Your reference: SSD-55968733  
Our reference: DA20230314001078-EIS & DA  
Exhibition-1

Date: Thursday 7 November 2024

**State Significant Development - Electricity Generating Works  
Request for comments - exhibited Environmental Impact Statement (EIS)  
BURROWAY SOLAR FARM 1955 EUMUNGERIE RD BURROWAY NSW 2821, 70//DP1251856**

Figure 1-1. Proposed site layout for the Burroway Solar Power Station.

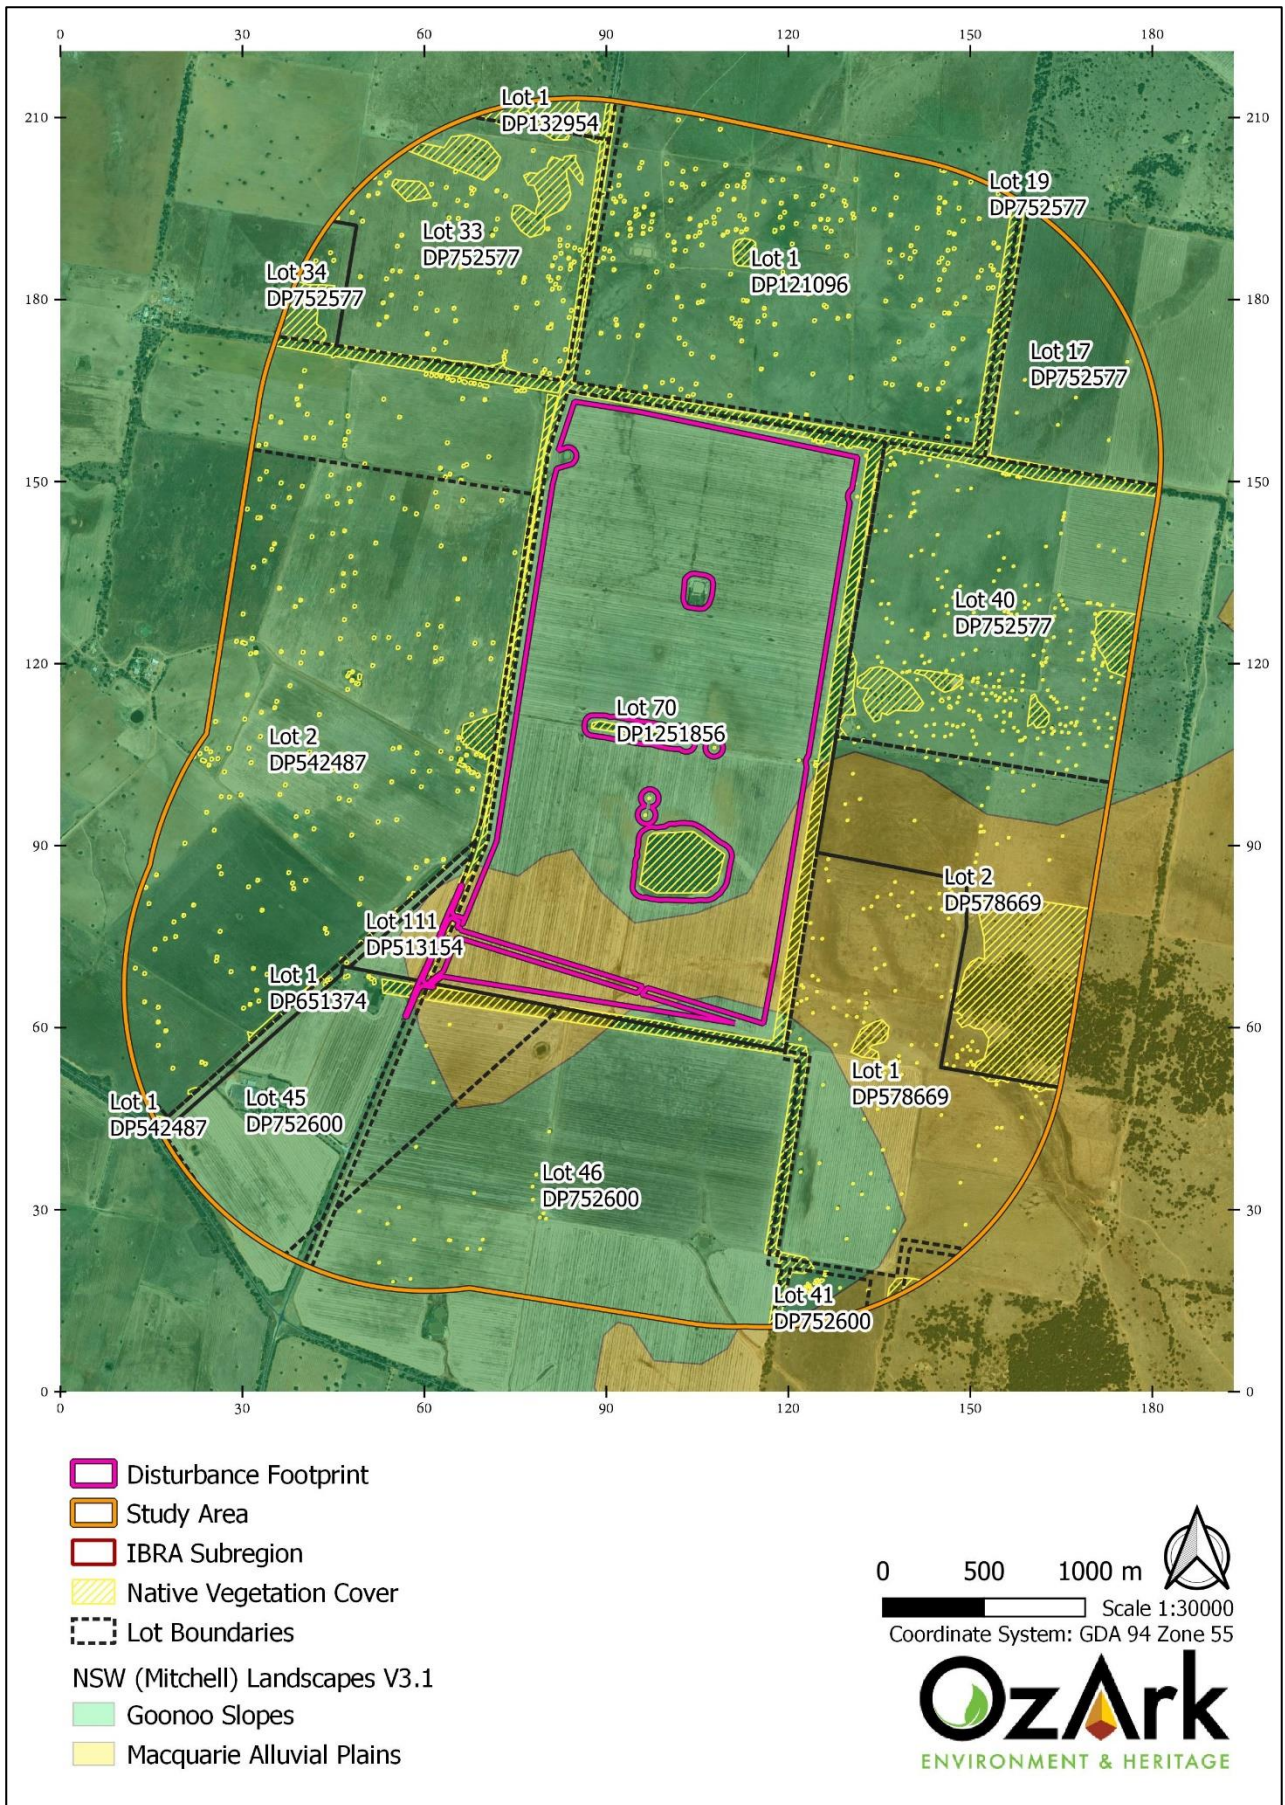
The EIS and Bushfire report does not adequately address the location of the BESS from a fire fighting access and suppression operation. The BESS is located greater than 1 km from the Eumungerie Road property access gate. The proposed internal access road traverses a the 132kV power line easement. Further the bushfire report states:

*"A dedicated static water supply of 20,000L for bush firefighting purposes is recommended at strategic locations within the solar farm, having consideration for essential equipment and accessibility e.g., near the main entrance."*

The NSW RFS requires the proponent to adequately justify the location of the BESS from a fire prevention, protection and suppression perspective.
